Meeting note

Project name	A417 Missing Link
File reference	TR010056
Status	Final
Author	The Planning Inspectorate
Date	17 May 2021
Meeting with	Highways England (the Applicant)
Venue	Microsoft Teams
Meeting objectives	Project update
Circulation	All attendees

A417 Missing Link – TR010056

Section 51 advice regarding draft application documents submitted by Highways England

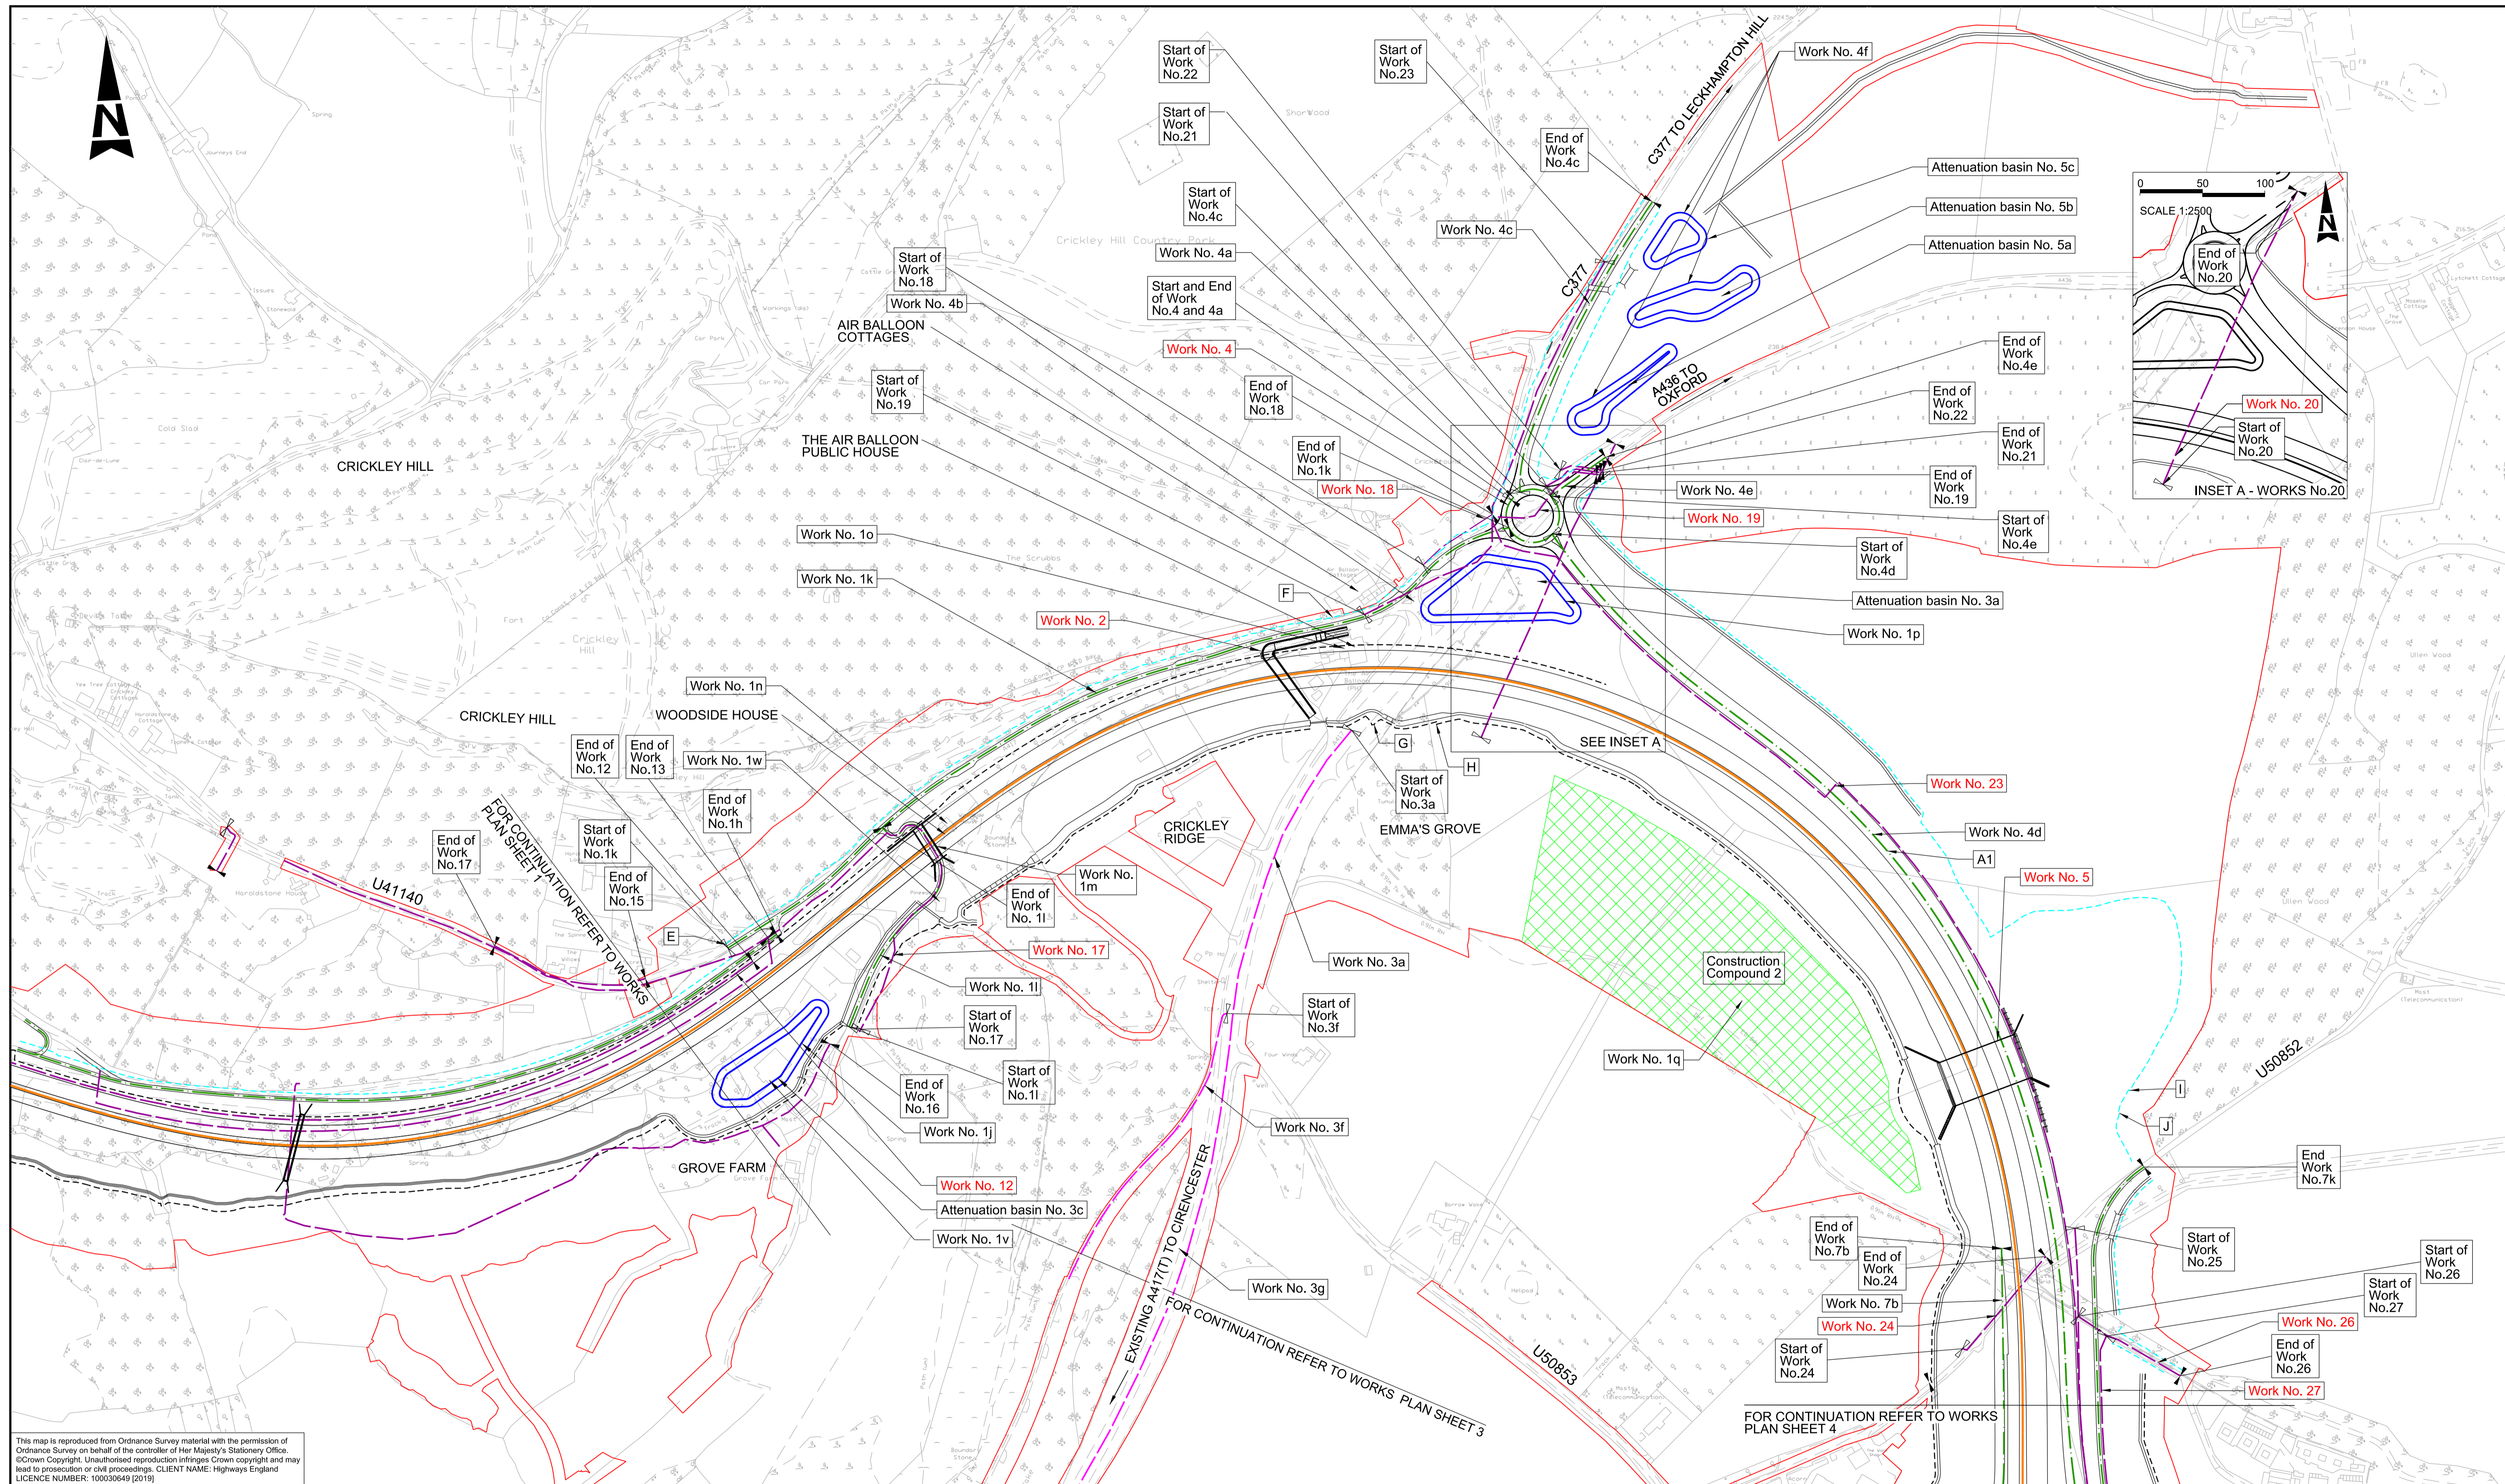
37.	Sheet 1 of 6	Work no. 1e is described in the dDCO as the construction of a culvert but is annotated as a drainage ditch.
38.	Sheet 1 of 6	Work no. 1f is described in the dDCO as the construction of an open channel. It is annotated on the Works Plans by a thin solid black line, however there is no corresponding item for "open channel" in the key.

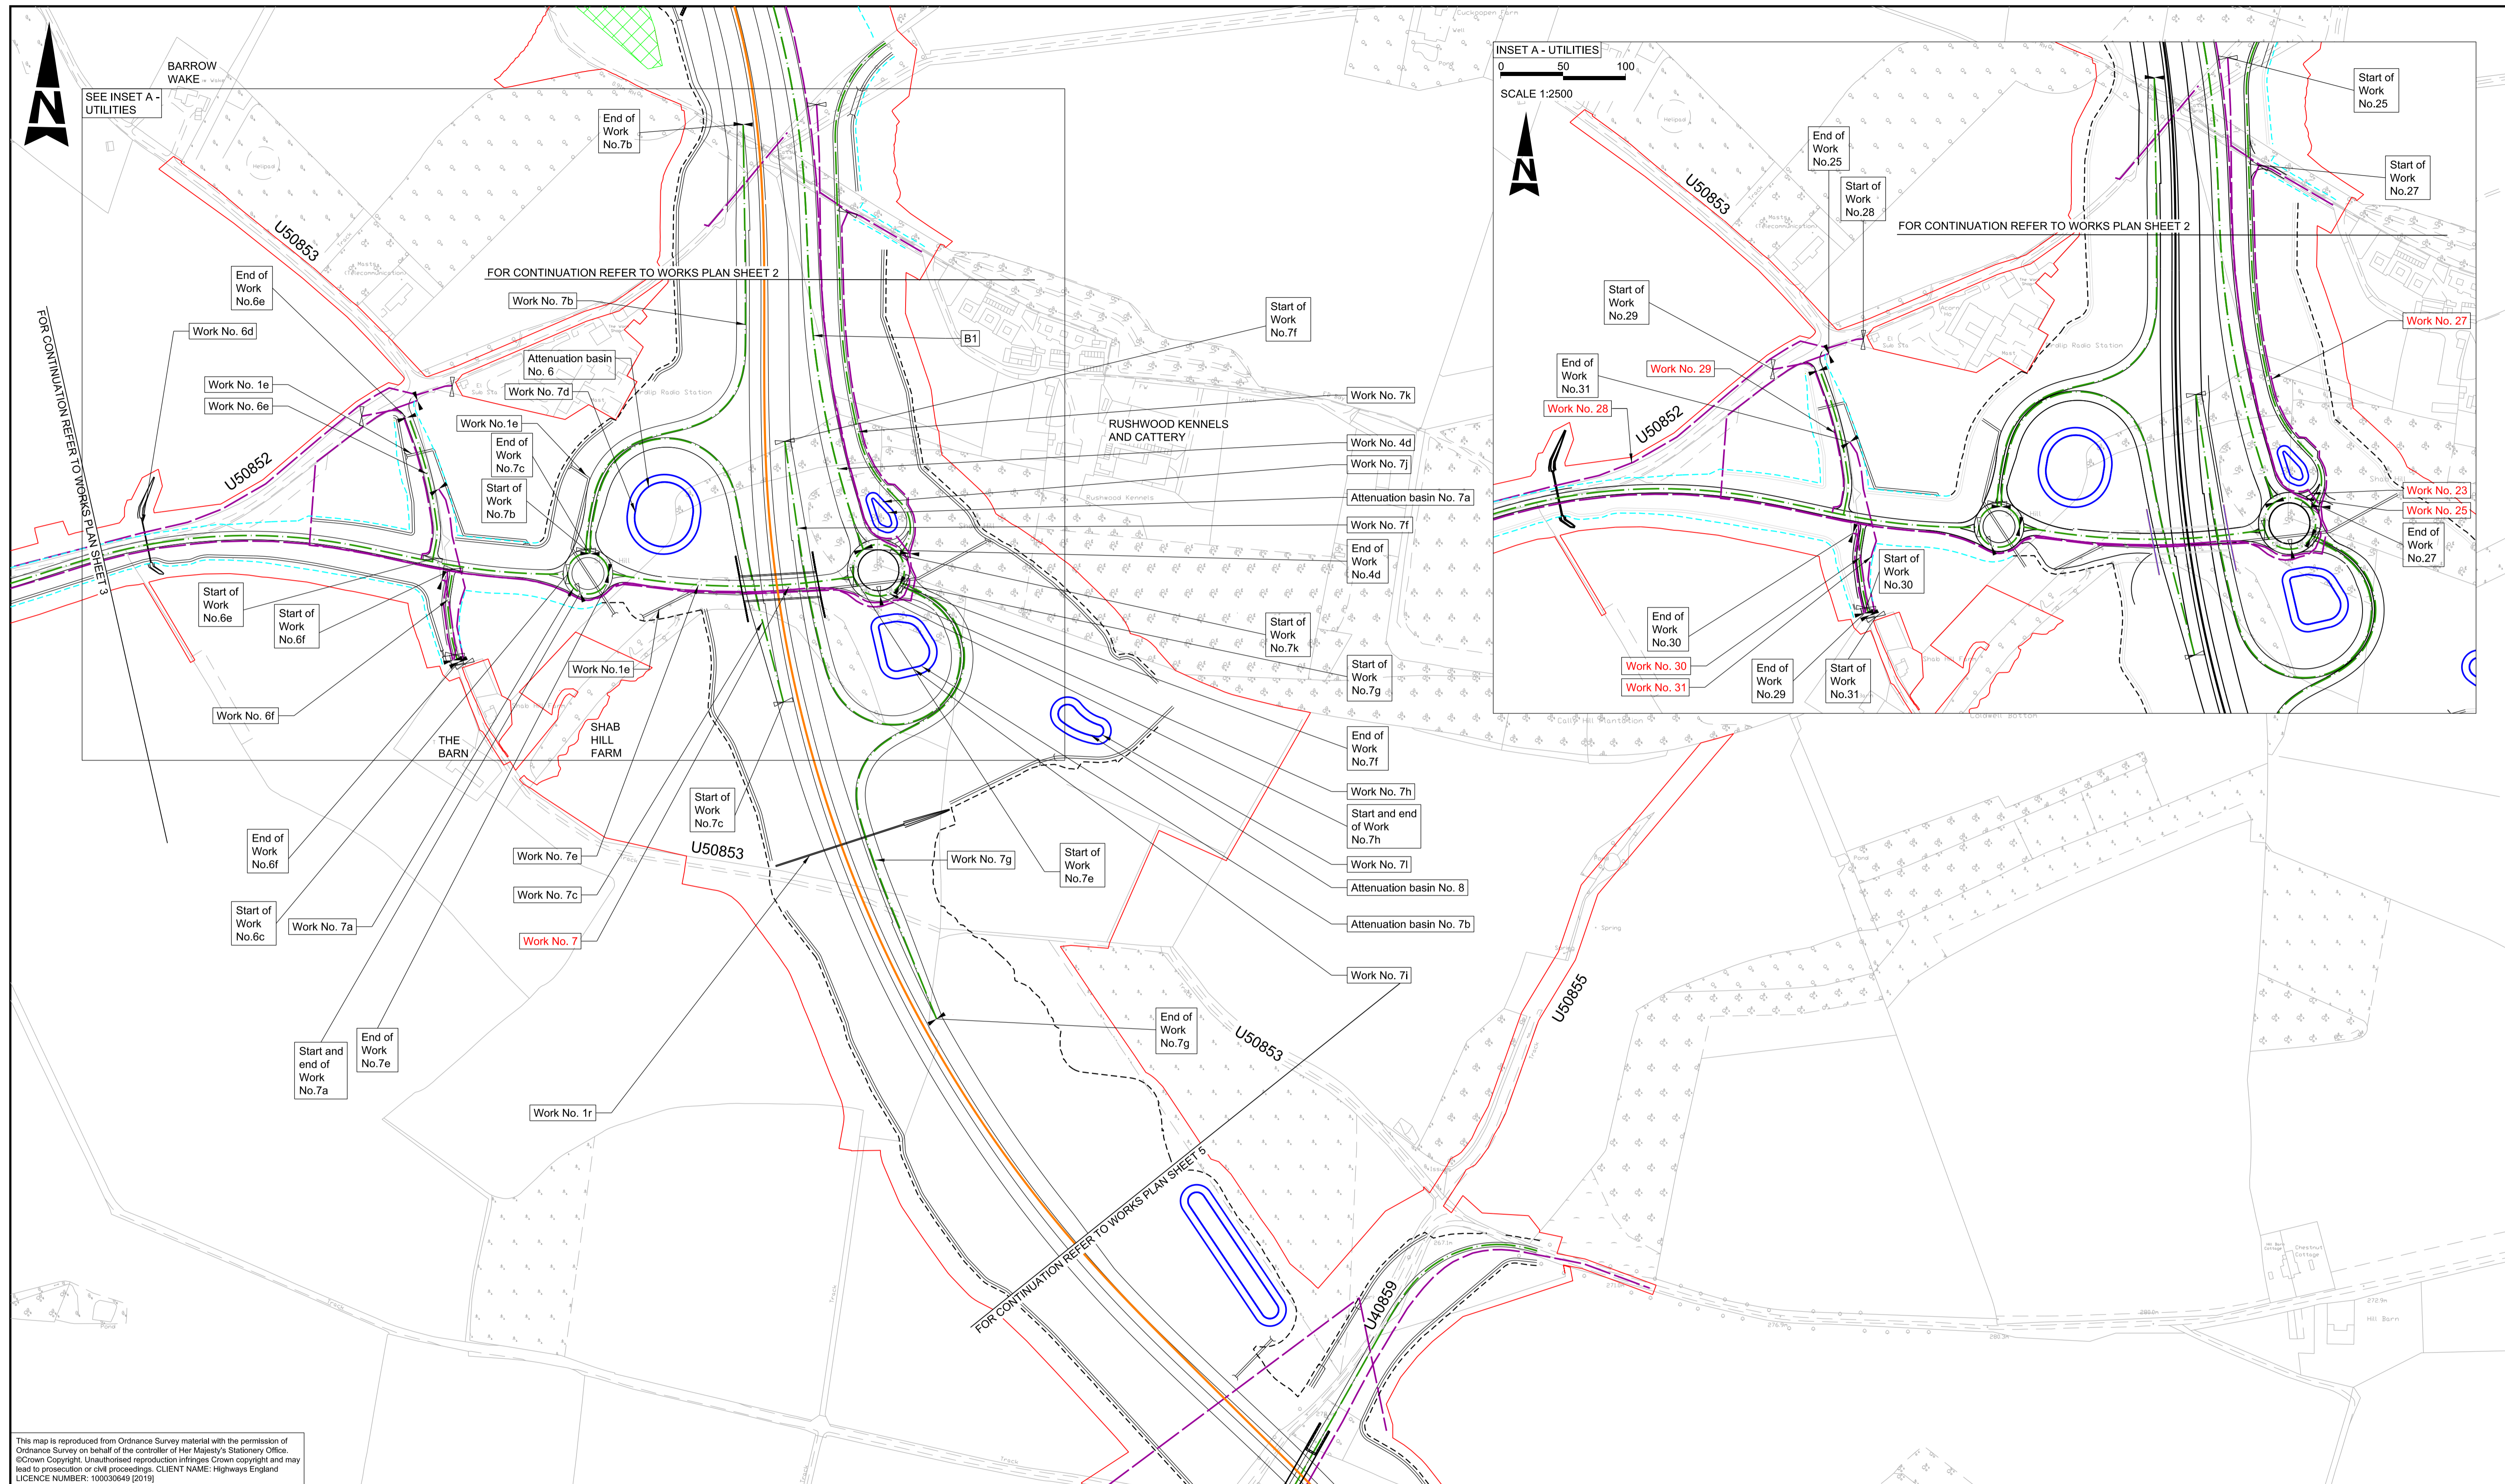
Draft Works Plans		
Ref No.	Work Plan Ref	Comment/Question
39.	Sheet 5 of 6	Car parks are not illustrated consistently eg see Work nos. 3e and 3c.
40.	Sheet 3 of 6	Regarding Work no. 16, it would be useful for the utilities centreline on the top of the sheet to be labelled for ease of reference. Given that this work is also shown on Sheet 1, should there be a continuation from Sheet 3 to Sheet 1?
41.	Sheet 2 of 6	Regarding Work no. 20, the linear power cable diversion work shown on Sheet 2 has no centre line and has no end point, so it is unclear what route the work follows and where it ends. It overlaps with Work no. 7k which makes it even less clear. The Applicant is advised to consider how to present these works in a way that is clear and reliable for the examination.
